# CITY OF ALBUQUERQUE

**Re: 4 Unit Townhouse Development  
1203 Griegos Rd NW  
Grading & Drainage Plan  
Engineer's Stamp dated: 3-05-15 (F14D070)**

Based upon the information provided in your submittal received 3/9/2015, this plan cannot be approved for Building Permit until the following comments are addressed.

4 UNIT TOWNHOUSE DEVELOPMENT GRADING AND DRAINAGE PLAN

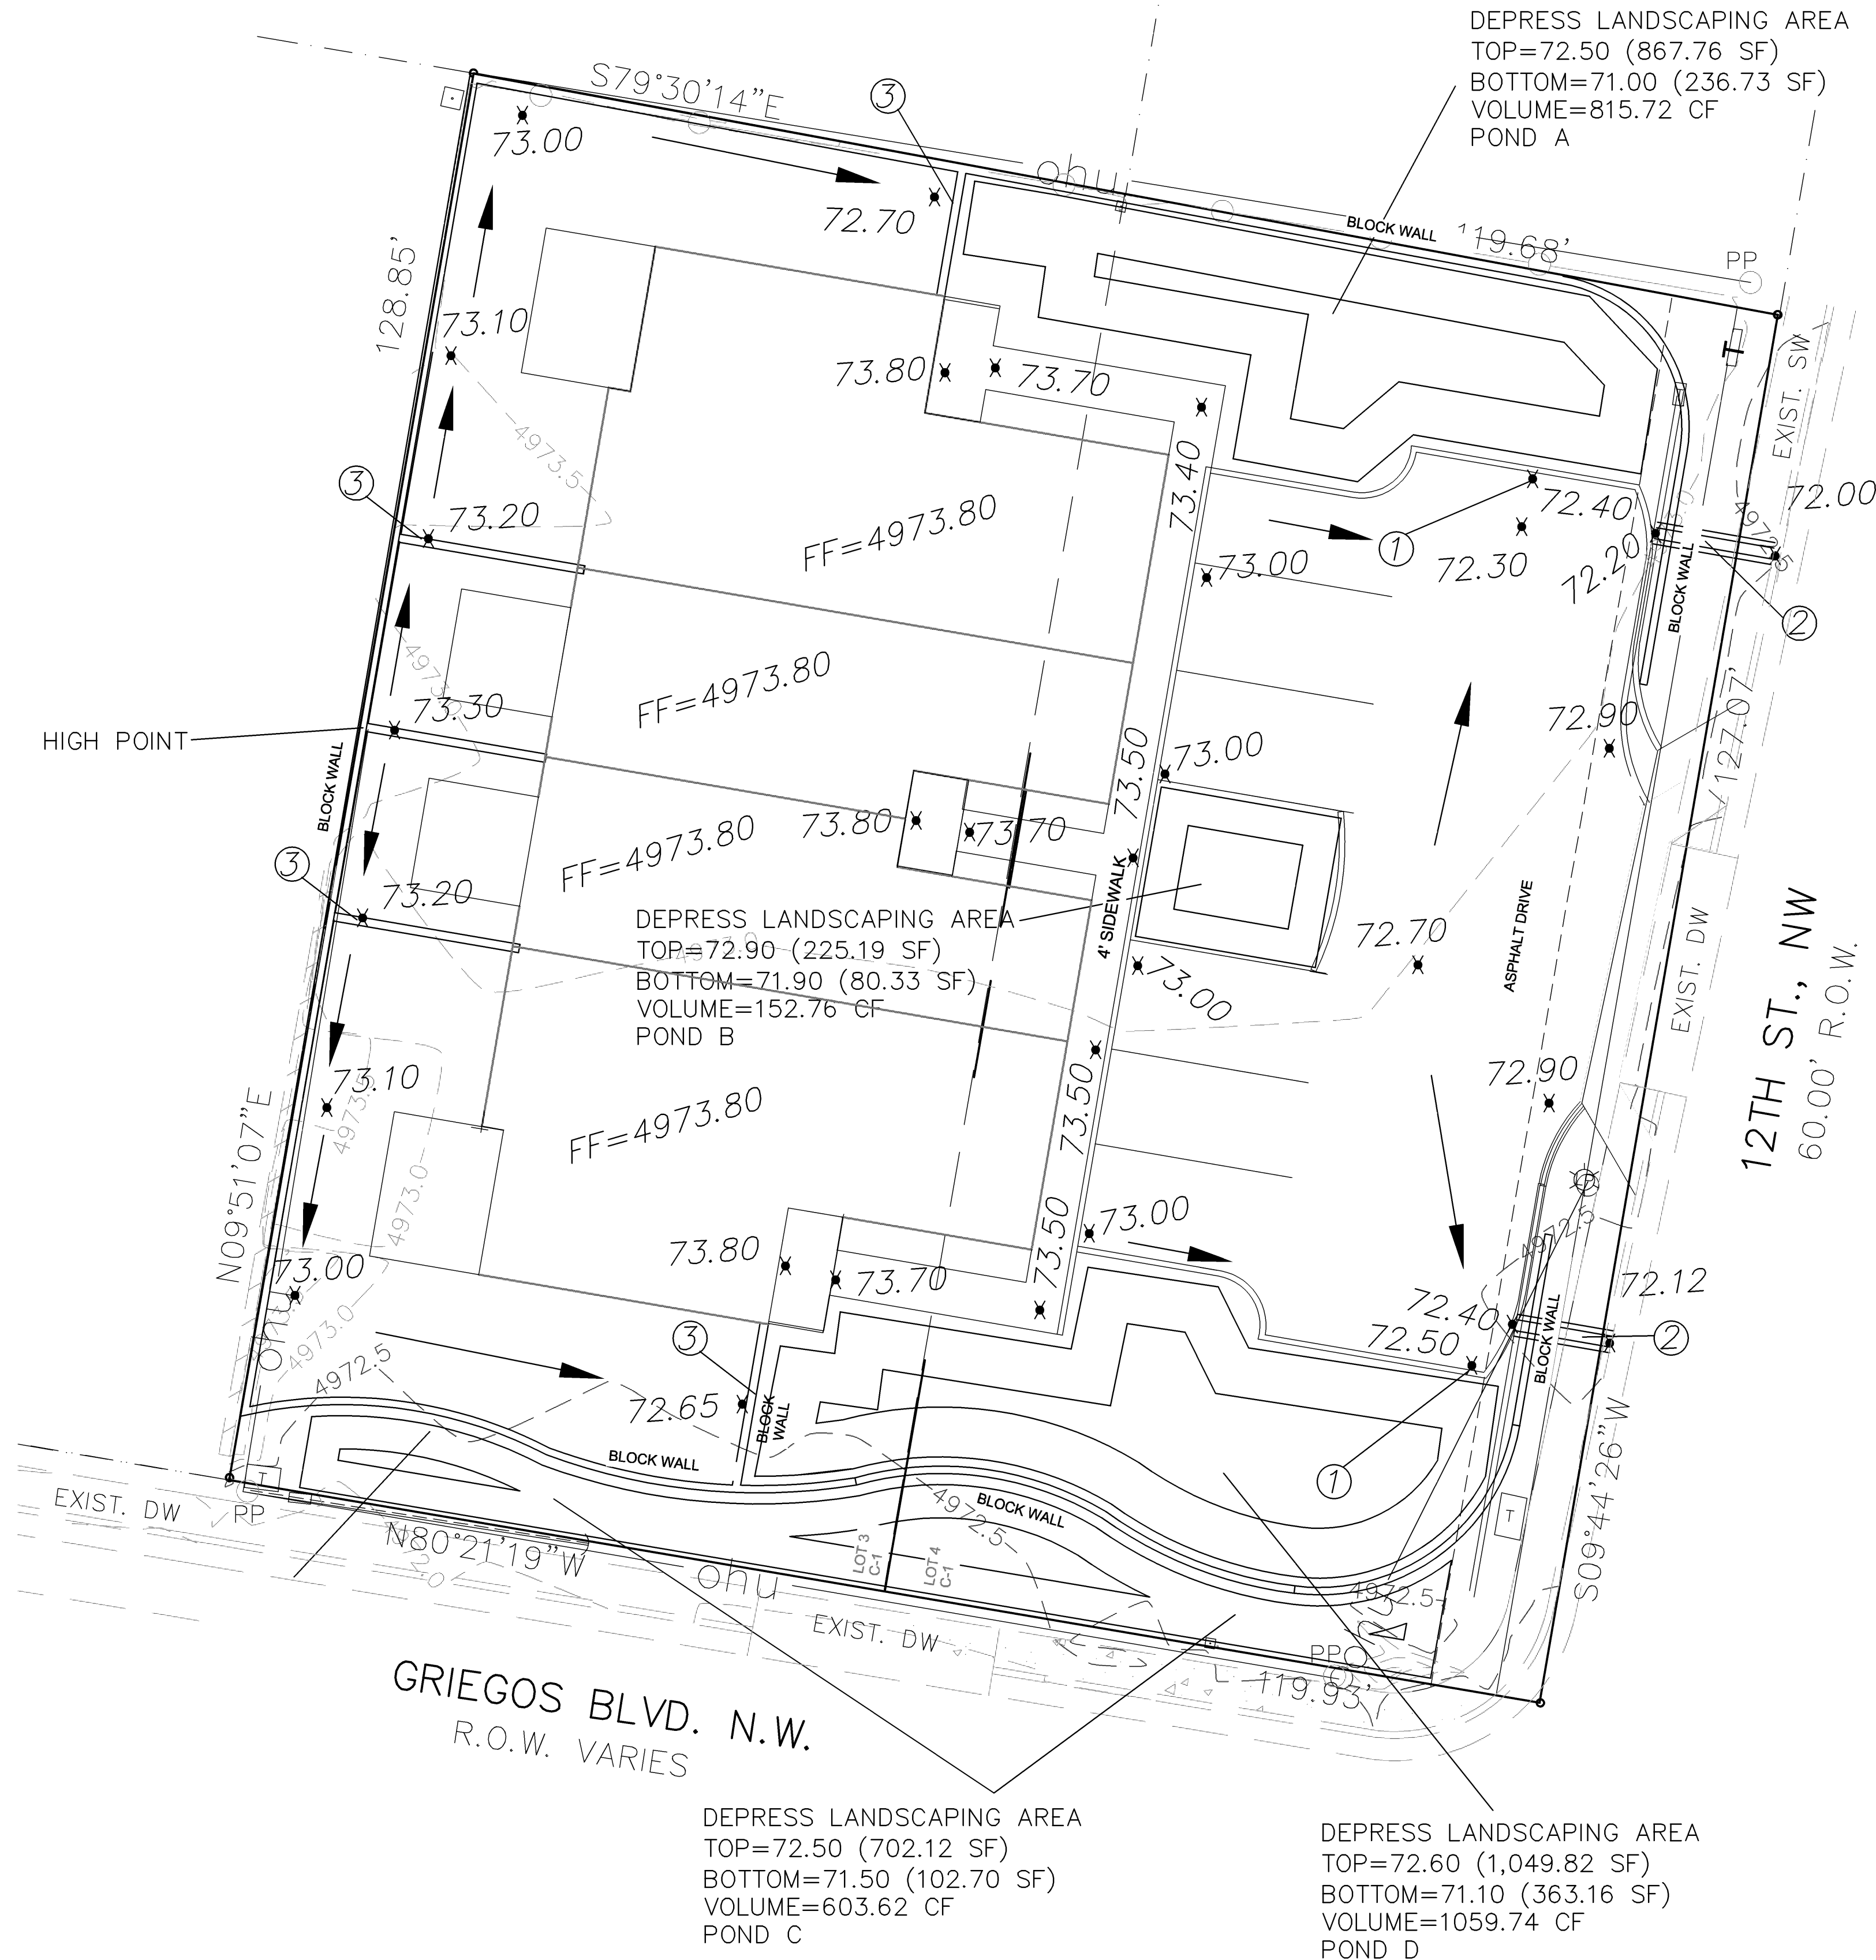
- Provide direction of roof flows. If flows are toward the front, how will these flows enter the ponding areas?
- Consider building #4 rebar spaced at three 3" on center to the wall openings.
- Move both sidewalk culverts closer to ponding areas. As they currently sit, it appears as though the flows from the parking lot will leave the site without entering the ponds for first flush requirements.
- Provide flow line spot elevations in 12<sup>th</sup> St. at entrance.
